HAYES STRUCTURAL

Date: May 12, 2025

Re: 25-FRM-089
Framing Inspection
Lot 45 Tobacco Road
254 Golden Leaf Farms Road
Angier, NC 27501
Permit No.: SFD2503-0173

At your request, a site visit was made to the above referenced single family residence under construction to inspect the garage portal framing concern noted by the inspector.

**B**  
5.01  
BUILDING SECTION THRU GARAGE  
1/8" = 1'-0"

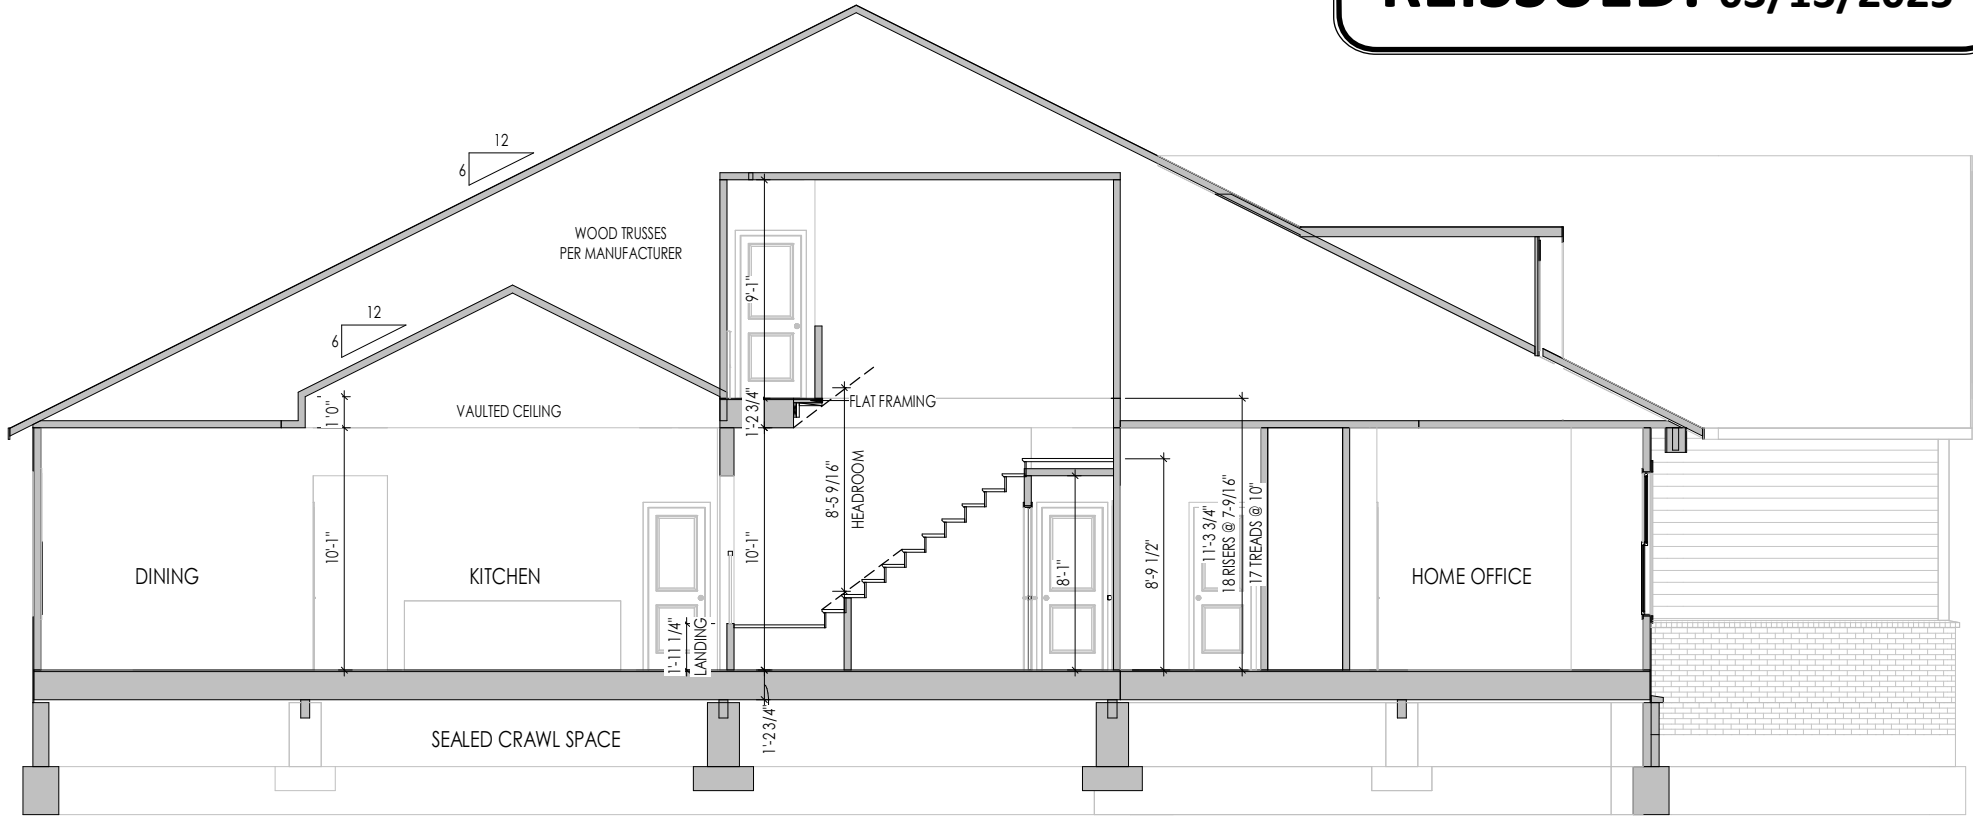
The 2x4 @ 16" o.c. pony walls above the garage door headers were measured to be +/- 5'-3" in height, exceeding the maximum allowable height for portal framing. The roof trusses above the front side of the garage span left to right to bear on the pony wall above the one-car garage door header. The roof trusses above the rear side of the garage span front to back, parallel to the pony wall above the two-car garage door header.

Sheath the inside of the right garage wall with 7/16" OSB attached with 8d nails spaced 6" o.c. along panel edges and 12" o.c. in the panel field. Install sheathing in continuous panels extending from the bottom of the headers to the tops of the pony walls. Brace the top of the pony wall above the two-car garage door header with 2x4x8'-0" ties spaced 4'-0" o.c. installed on top of the truss bottom chords extending inwards from the gable truss. Attach the ties to each interesting bottom chord below with (2) 10d nails. This prescribed configuration will provide the required support for all imposed lateral loads.
